City of Portland, Maine - Building or Use Permit Application
389 Congress Street, 04101 Tel: (207) 874-8703, Fax: (207) 874-8716

| Permit No: 02-0286 | Issue Date: MAR 25 2002 | OB#: 388 | H001001 |

Proposed Project Description:
Install 30' above ground pool

PLOT PLAN FOR 30' ROUND ABOVE-GROUND POOL AT 52 ABBY LANE PORTLAND

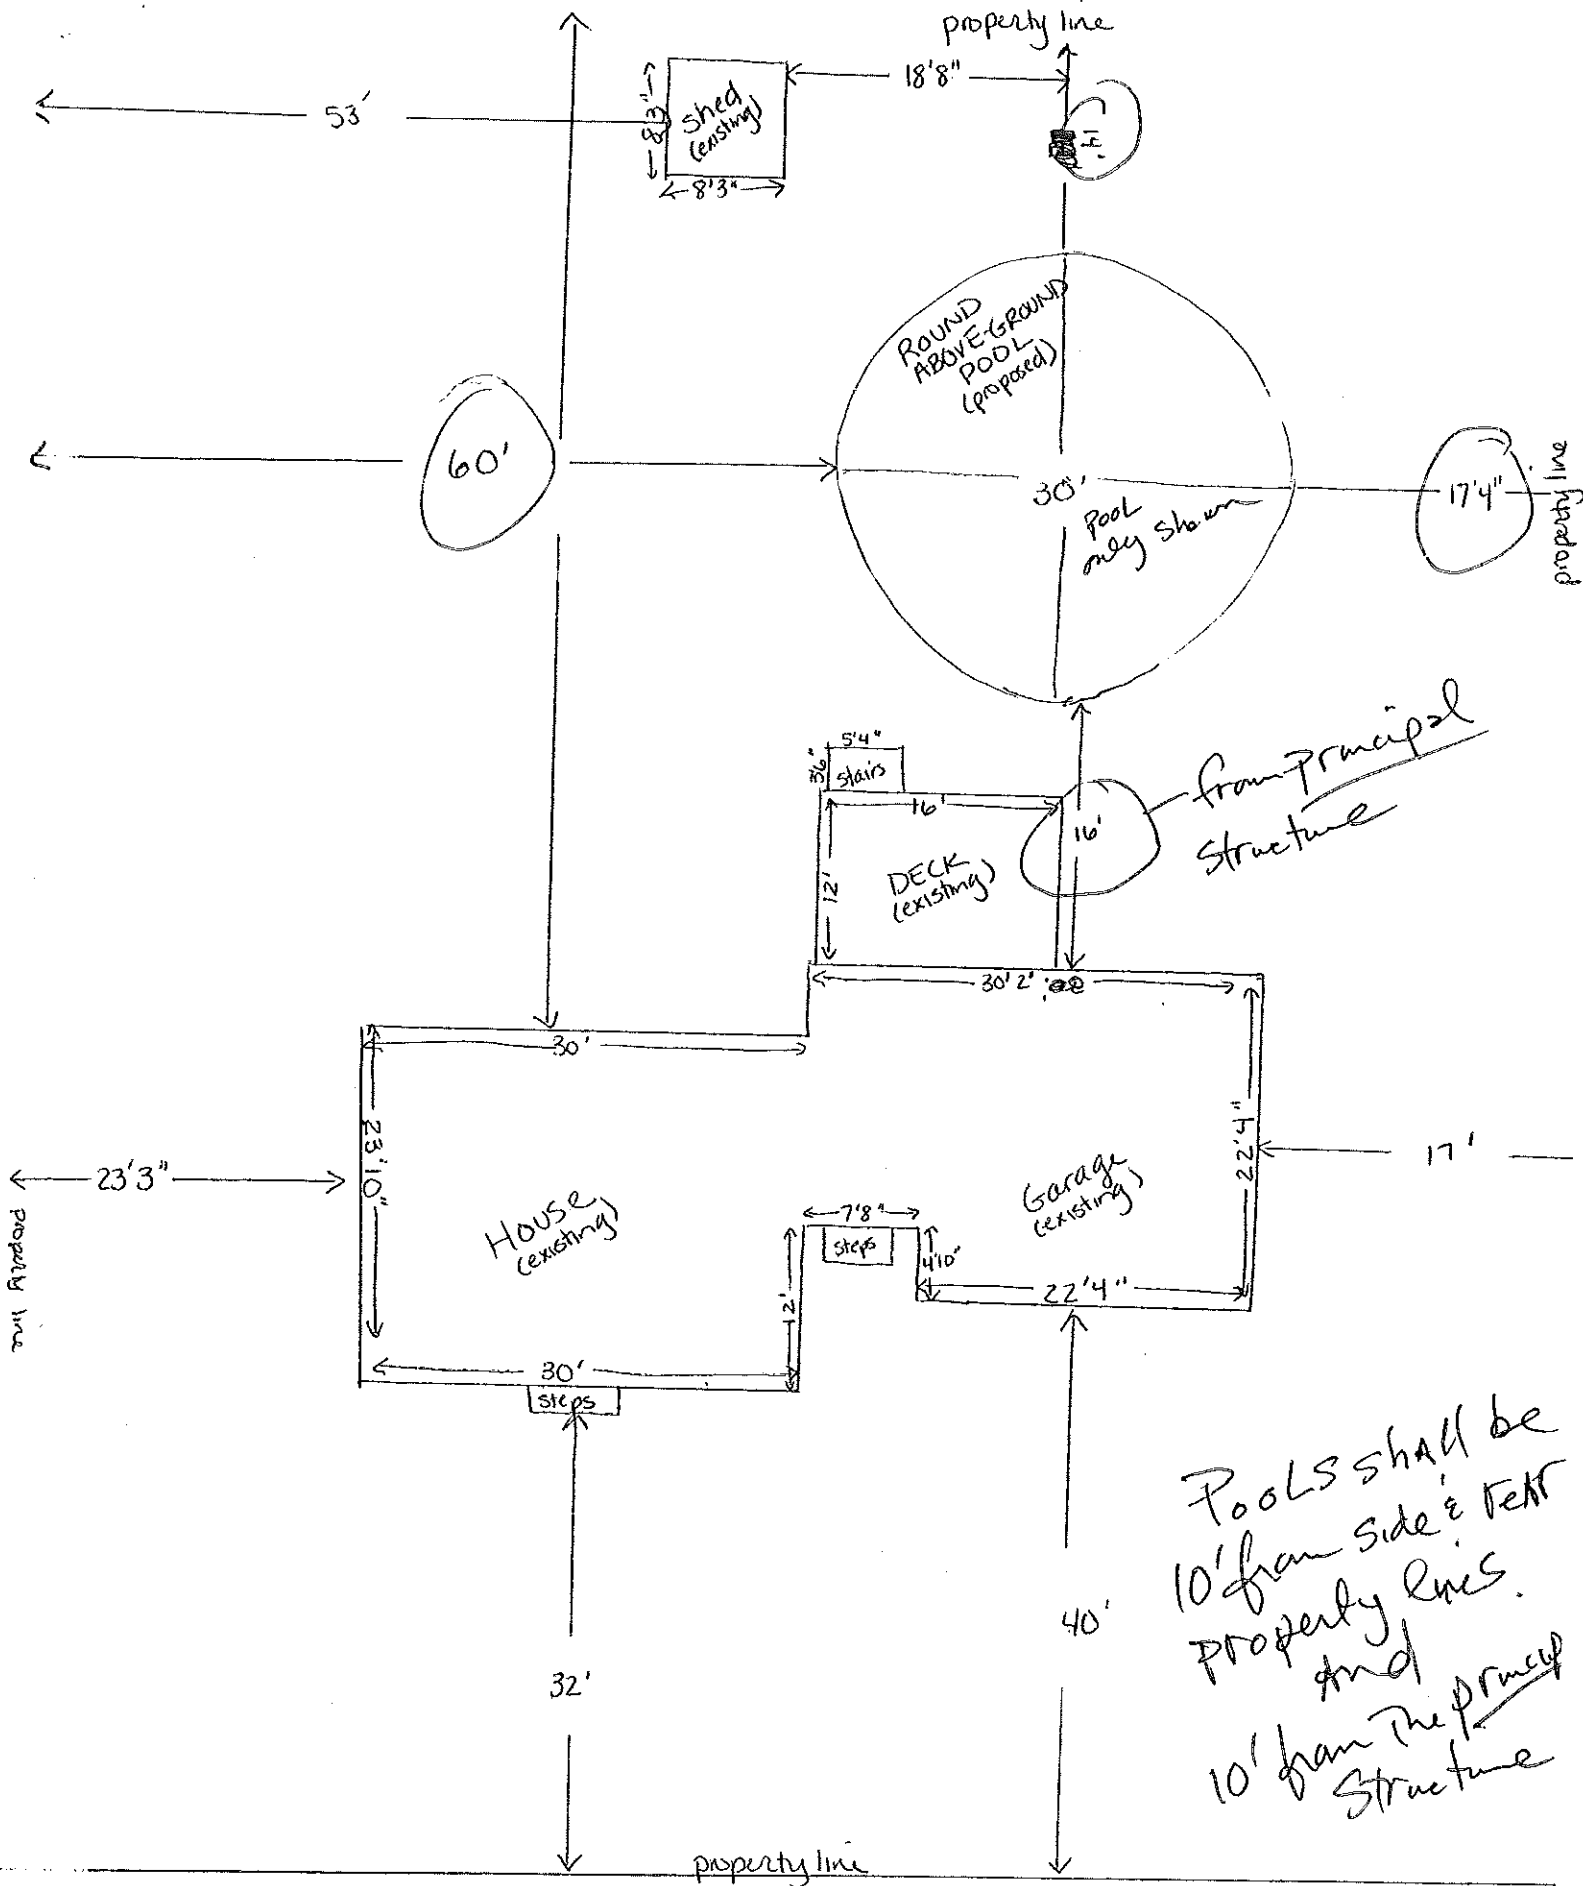
Please note that your pool is closer than 10 feet to your exterior deck. This deck could be in structural jeopardy if this pool were to fail. The Zoning Ordinance requires a 10 foot setback to principal structures (your main living structure). Please take care to protect your accessory deck.

Building Plan
 30' Round above-ground
 pool - 52 Abby Ln.
 Portland

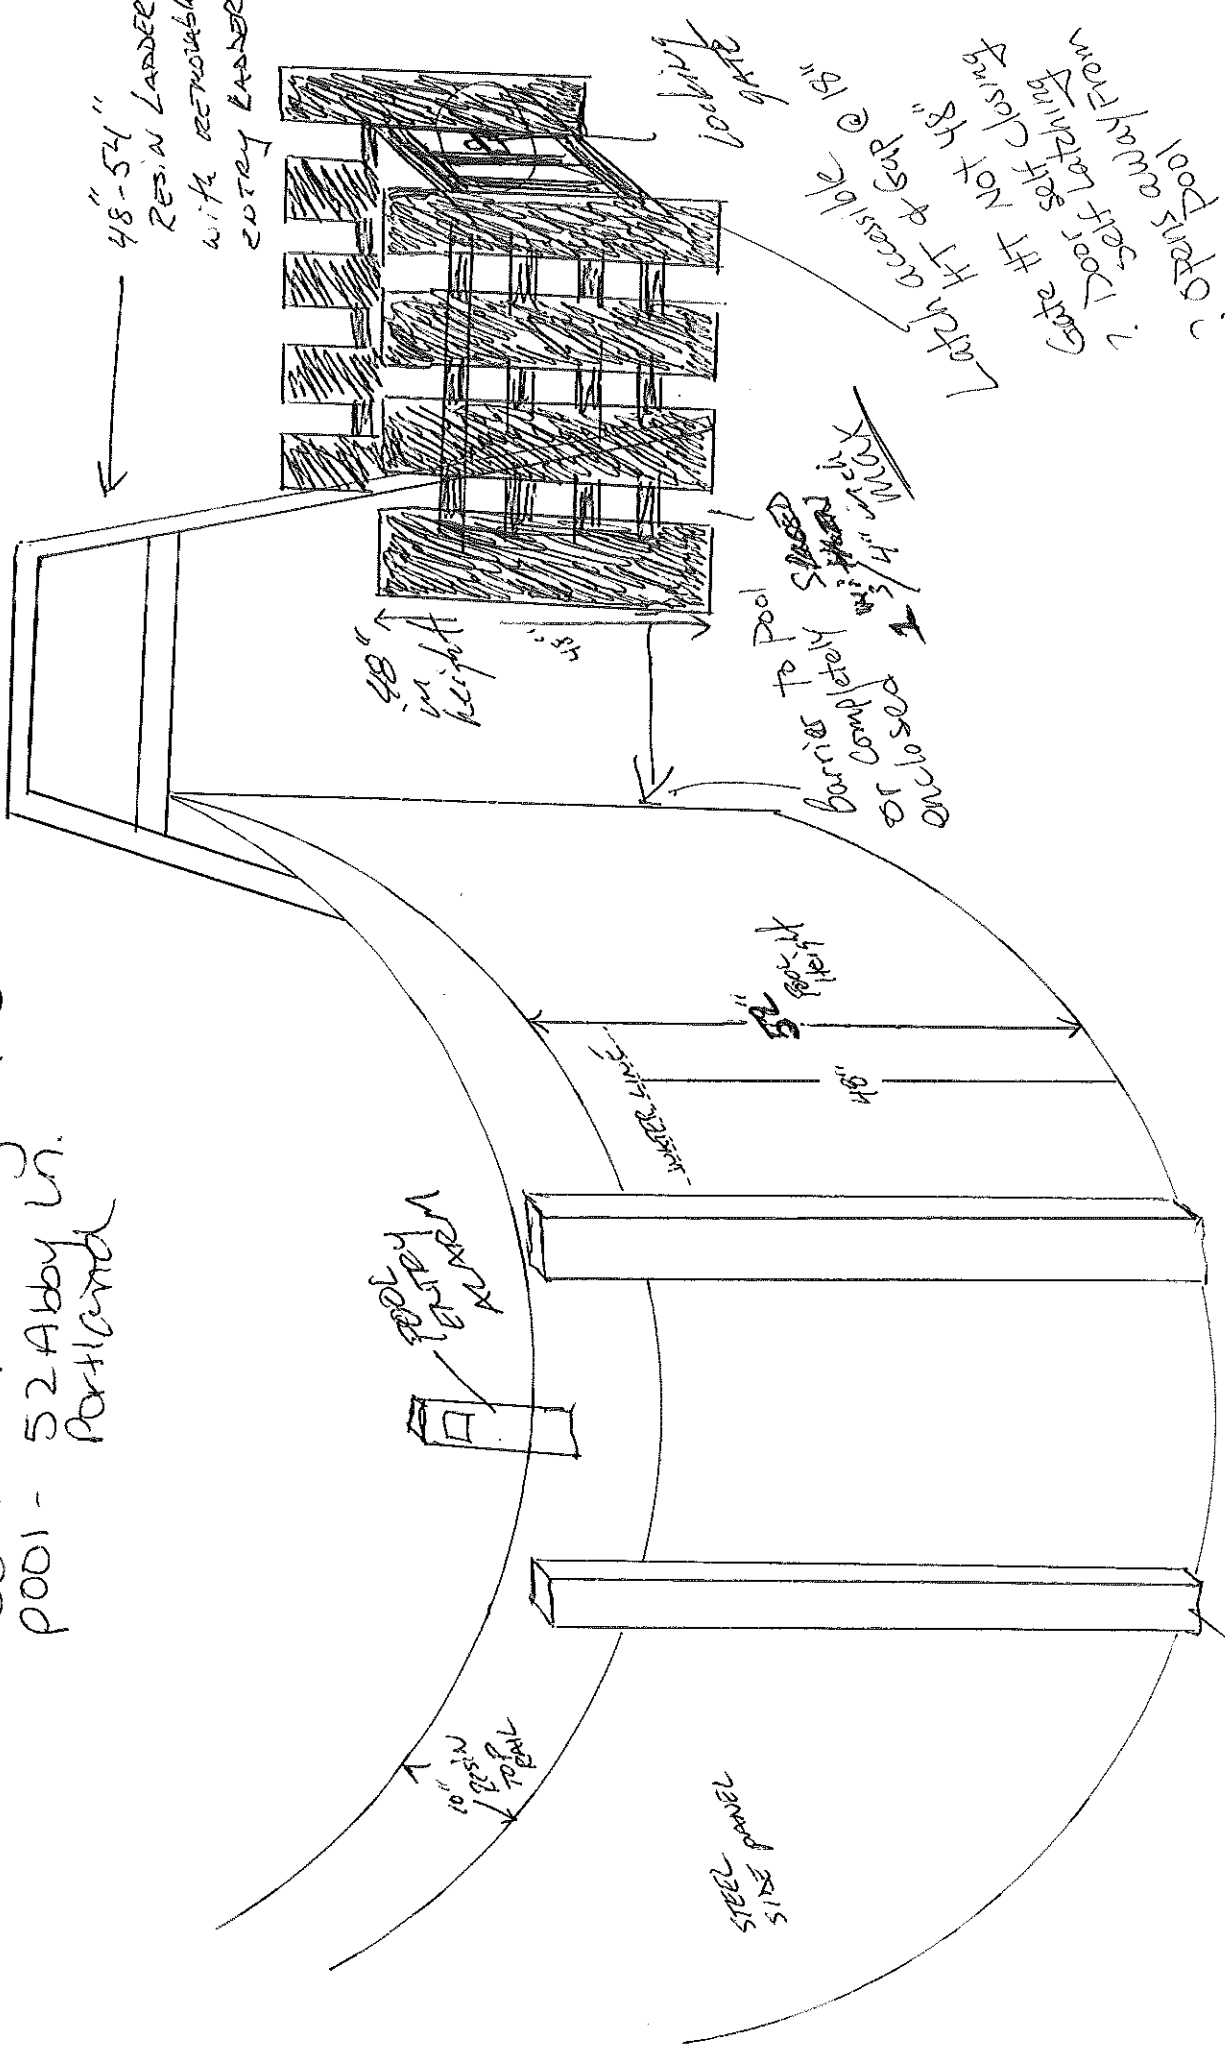
3/20/02 left message w/ Applicant to call concerning code issues JB

3/20/02 Mr. Knopf called - Reviewed code requirements - he will submit changes. JB

Latch accessible
 HT & Gap @ 18"
 Gate HT Not 48"
 ? Door self closing
 self latching
 ? opens away from
 pool

3/21/02 submittal addressing code issues ok to approve. JB
